Application for a Lawful Development Certificate for an Existing Use or Operation or Activity,  
including those in breach of a planning condition

Queens Walk

Loft Conversion with Velux

The application is for a Certificate of Lawful Development for the conversion of the roof space to habitable use to include a rear dormer window, 2 front roof lights and the conversion of the roof from a hip to a gable end, with a new gable end window.

DRG. No. 3397-01 REV. A

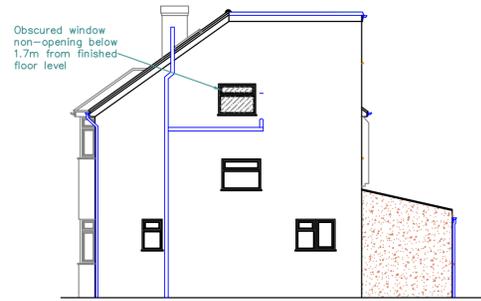
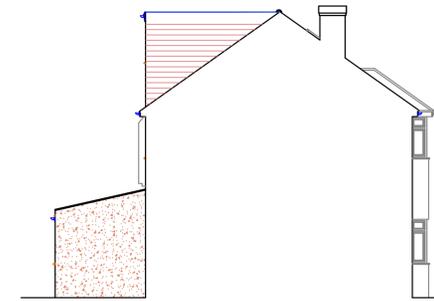
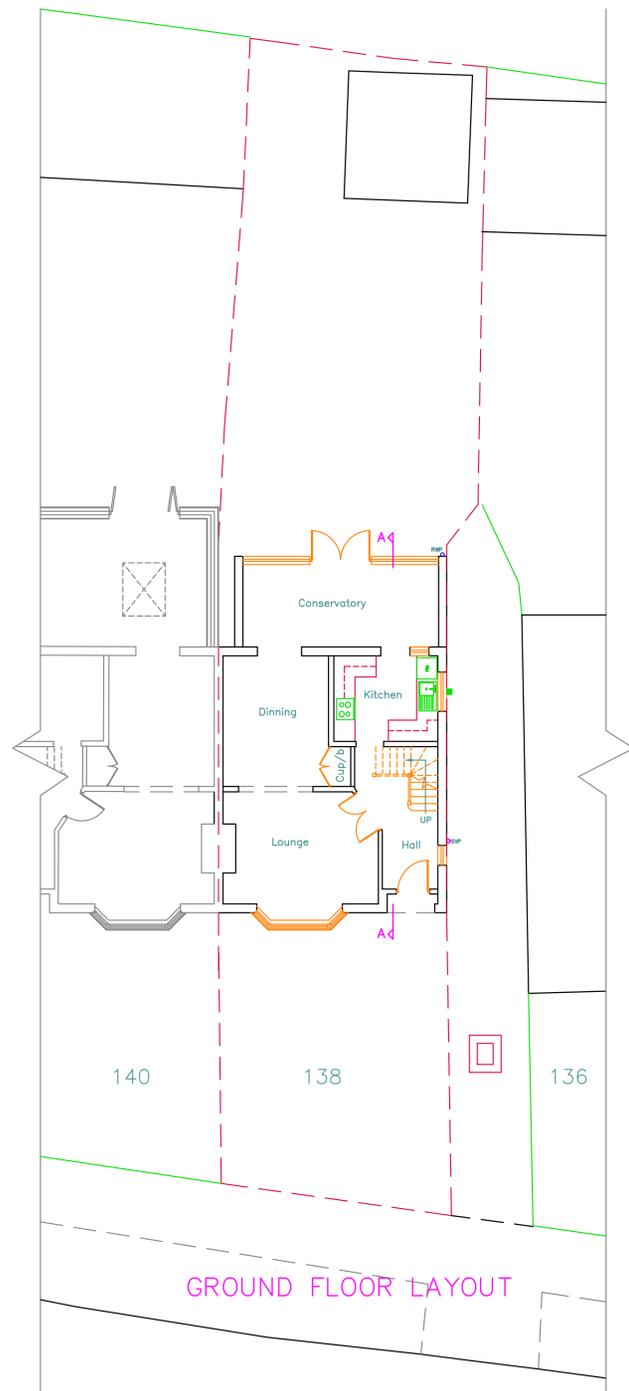
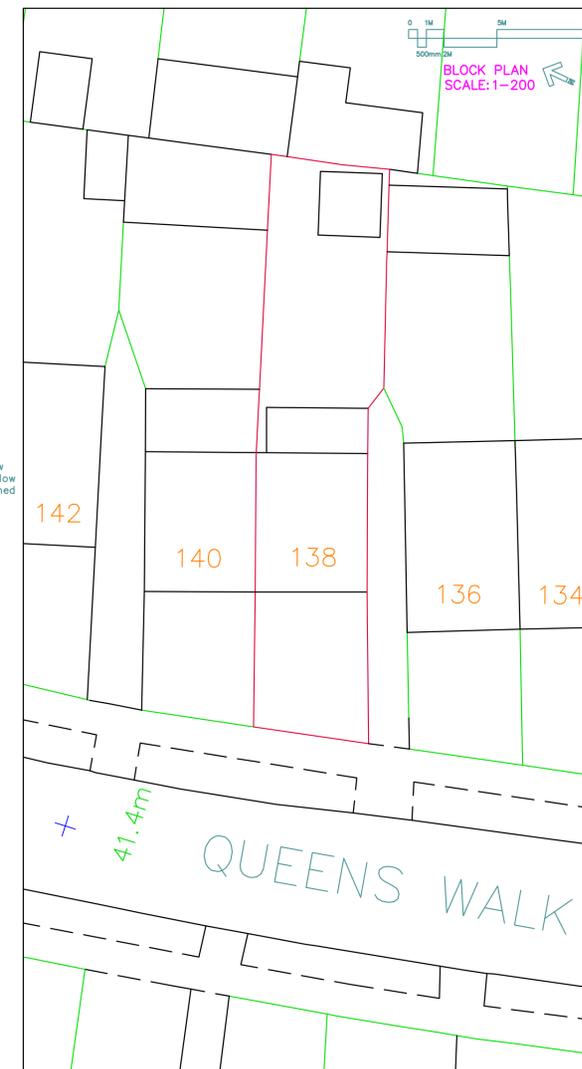
- i) Be no higher than the existing roof line.
- ii) Not extend beyond the plane of an existing roof slope which forms the principal elevation of the dwelling which fronts a highway.
- iii) Not exceed 50 cubic metres. (semi-detached property)
- iv) Not include a veranda, balcony or raised platform.
- v) No confirmation that the roof lights would not protrude more than 150mm beyond the plane of the slope of the original roof . CONFIRMATION HAS NOW BEEN GIVEN VIA NOTE ON DRAWING
- vi) Have side windows obscurely glazed and non opening below 1.7 m.
